Ann Machado - FW: Permit #2104-01420 - 207 Brighton Ave. - Sign permit

Subject: Permit #2104-01420 - 207 Brighton Ave. - Sign permit

I have completed my initial zoning review and at this point I can't sign off for zoning. I have attached the sign ordinance for what is allowed signs for gas stations. This property is in the B-1 zone.

3'-0" x 4'-0" Building sign

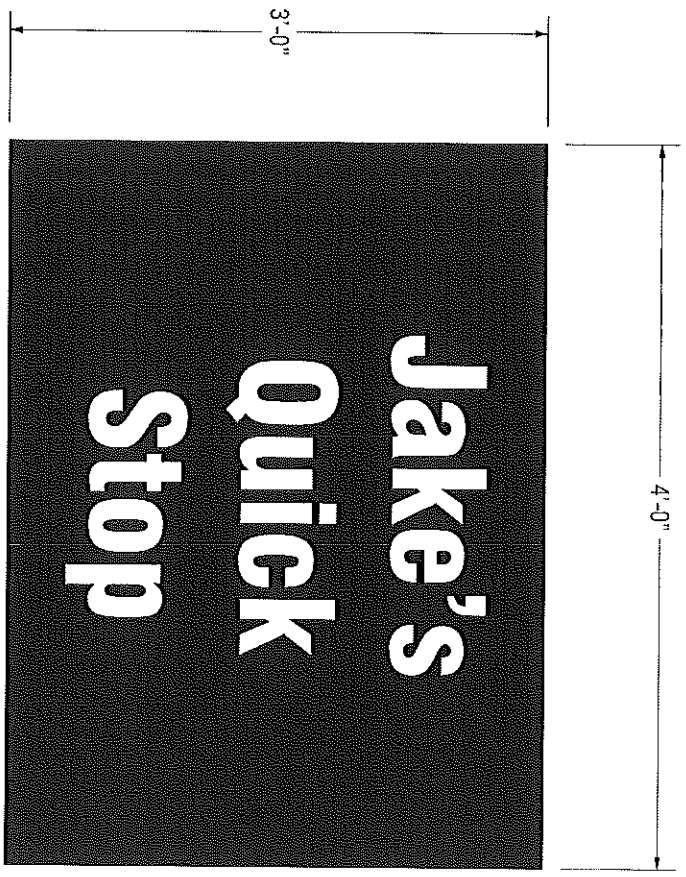
The two building signs are allowed' with the principal sign max square footage as 30 sf and the additional major activity as 10 sf. The table also states that the vertical dimension for a building sign is 2' so neither sign meets that criteria. Jake's is 3' x 4', 12 sf total. The gulf sign is 21.4 sf - 3'8" x 5'10". These also need to be revised.

CROPPED SUNRISE LOGO FOR 48" CANOPY FASCIA (GLF-48-CAB)

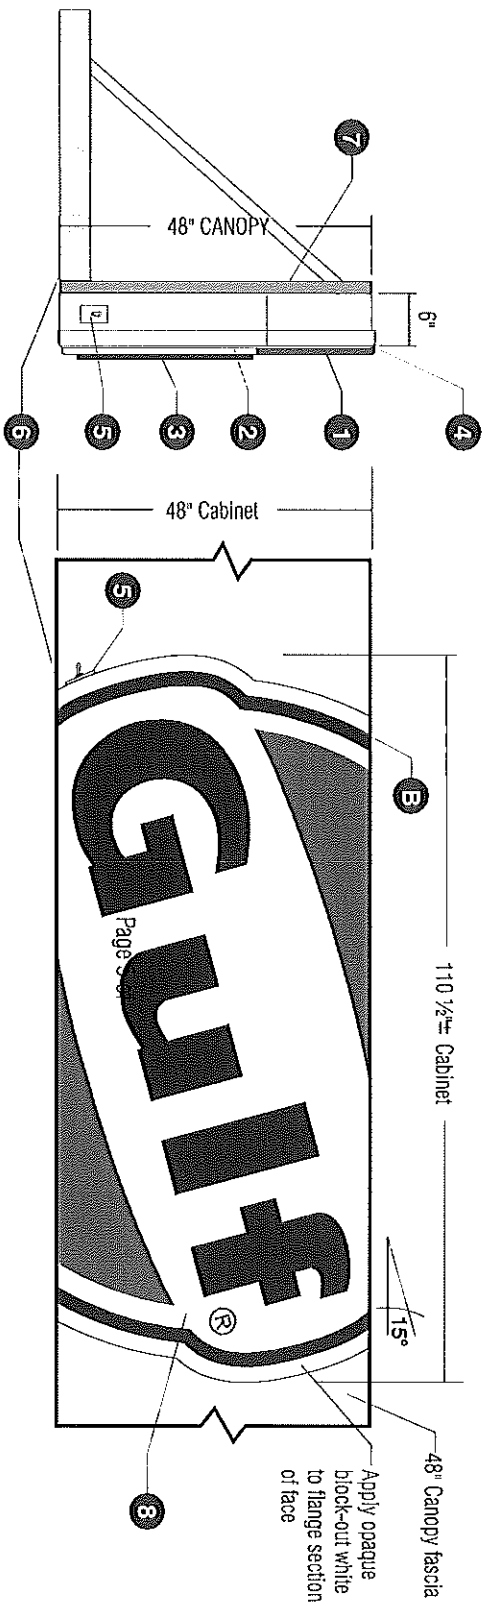
The proposed canopy signs are too big. The square footage can't exceed 20 sf for each. Just the gulf part is over ($48" \times 110.5" = 36.83$ sf) and that does not include the cloud part. You need to submit revised plans that meet the 20 sf total.

# 5'-0" X 6'-1" MID CONFIGURATION

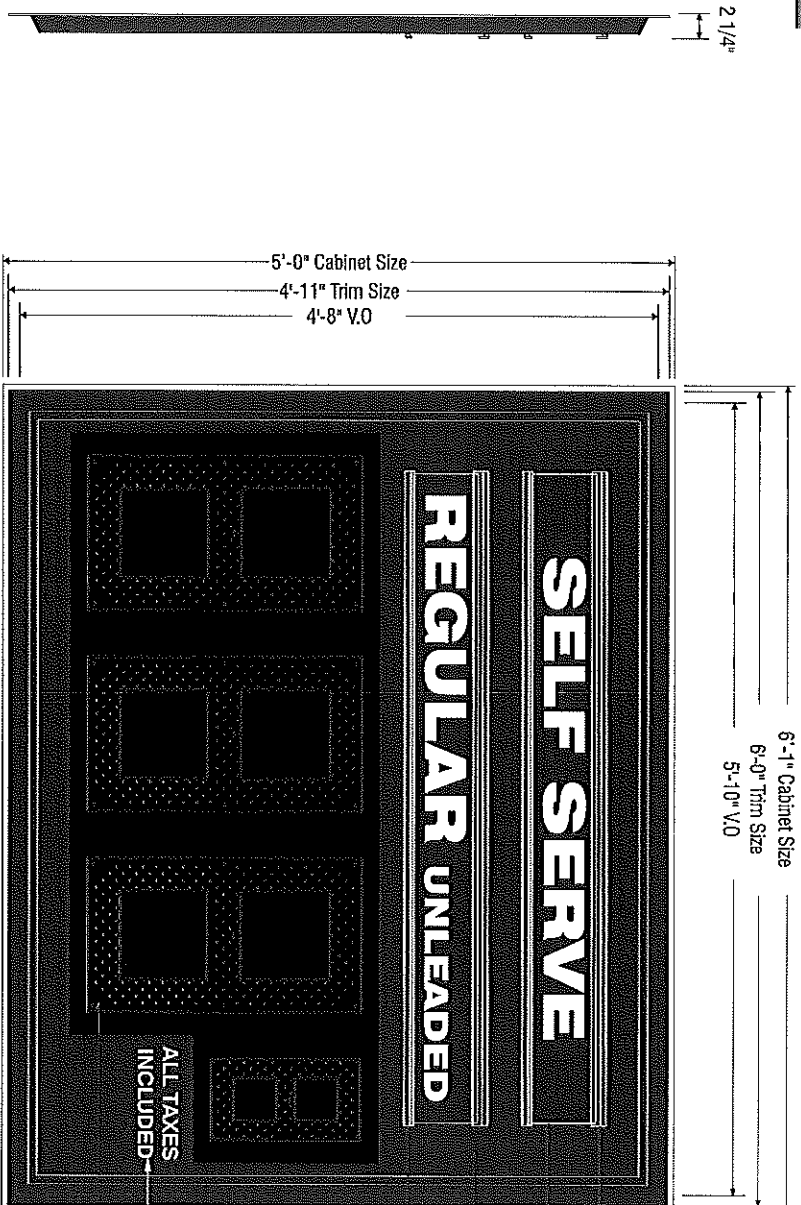
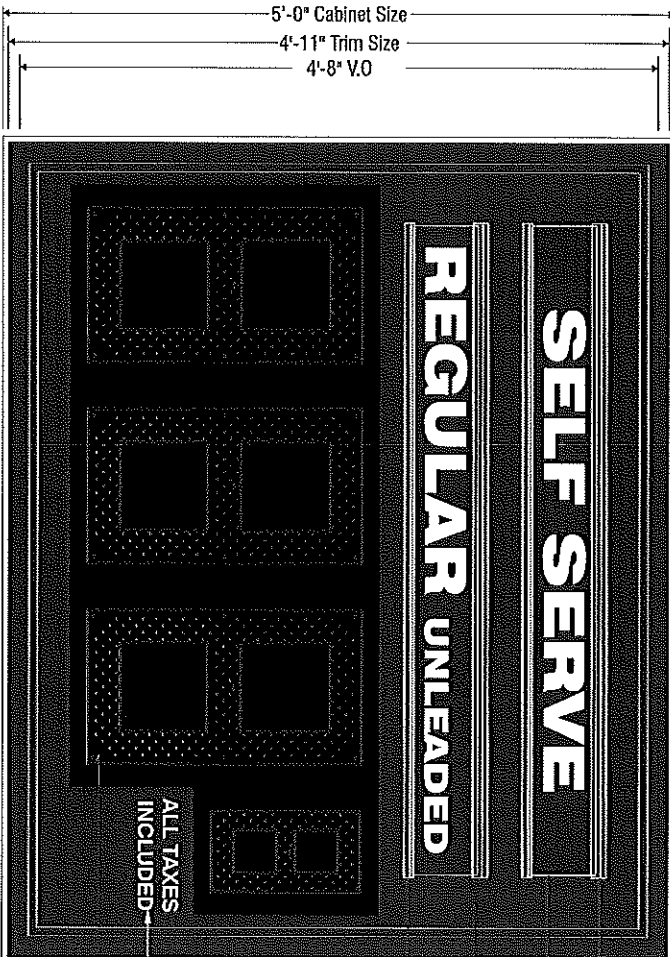
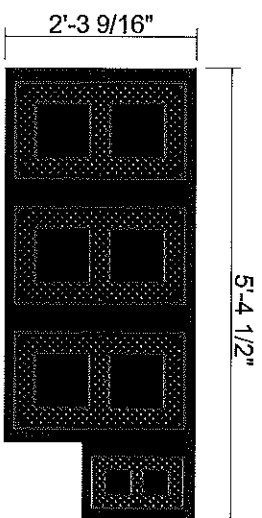
The last permit we have on file for the free standing sign shows the top panel as 6' x 6' the price panel as 4' x 6' and the message panel as 6' x 3.5'. The total square footage is 81 sf. The sign was 19.5' tall. This is larger than what the table allows. You are proposing 36 sf for the gulf sign, 30 sf for the price sign and I don't know what the square footage of the existing message sign is. You need to confirm the size of the message board and the overall height of the sign. If the total square footage of the sign is 81 sf and not taller than 19.5' it will be OK.
